DEVELOPMENT FACILITATION TEAM

Project Number: 2019-002639

200 Lomas NW

200 LOMAS ALBUQUERQUE, NM	DRAWN BY AS
	SIDEWALK VARIANCE EXHIBIT	DATE 06-04-2025
	TIERRA WEST, LLC 5571 MIDWAY PARK PLACE NE ALBUQUERQUE, NM 87109 (505) 858-3100 www.tierrawestllc.com	SHEET # EX-1
		JOB # 2025015

SKETCH PLAN

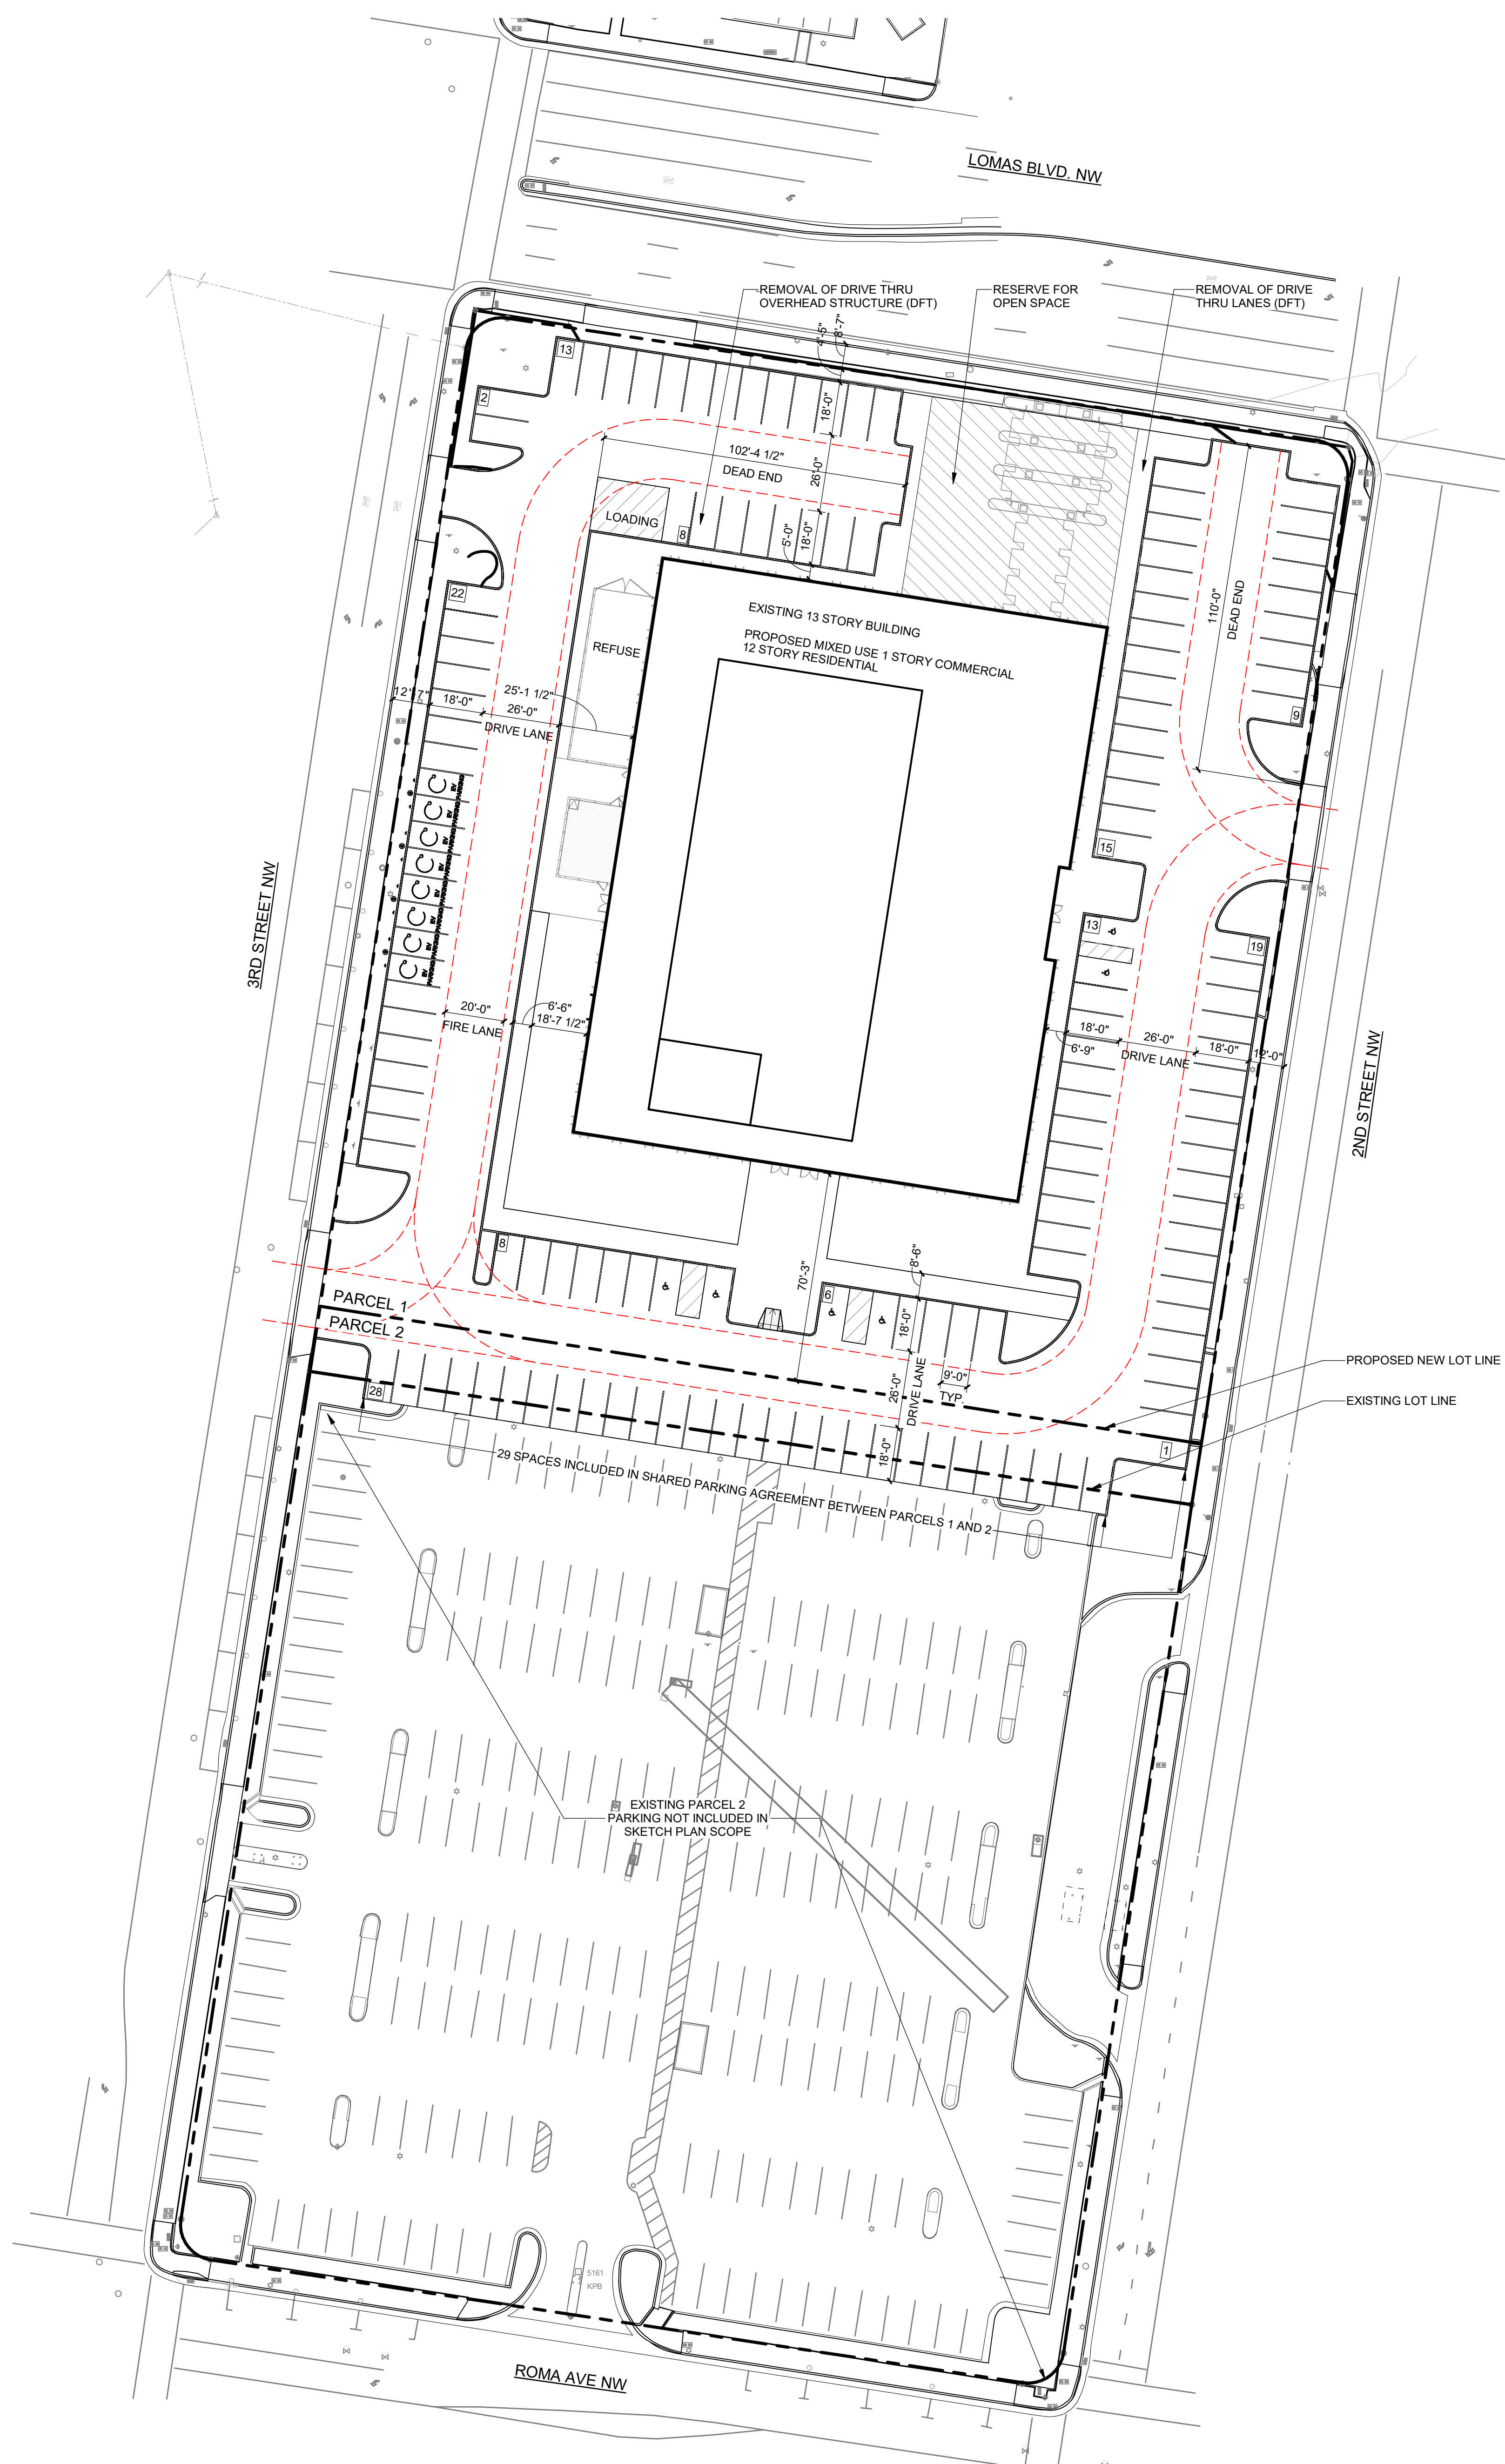
1. Lomas, 2nd, and 3rd are Principal arterial require 10' sidewalks and 6'-8' landscaping buffer. Existing widths are 7' along 2nd and 3rd, 8' along Lomas, require to be widened to 10'.
2. Roma is local road requires 5' sidewalk and 4'-6' landscaping buffer, the existing 7' sidewalk is in compliance.
3. Any future development will require an approved TCL prior to site plan or building permit. Also, a Traffic Scoping Form would need to be submitted to determine if a TIS would be required.
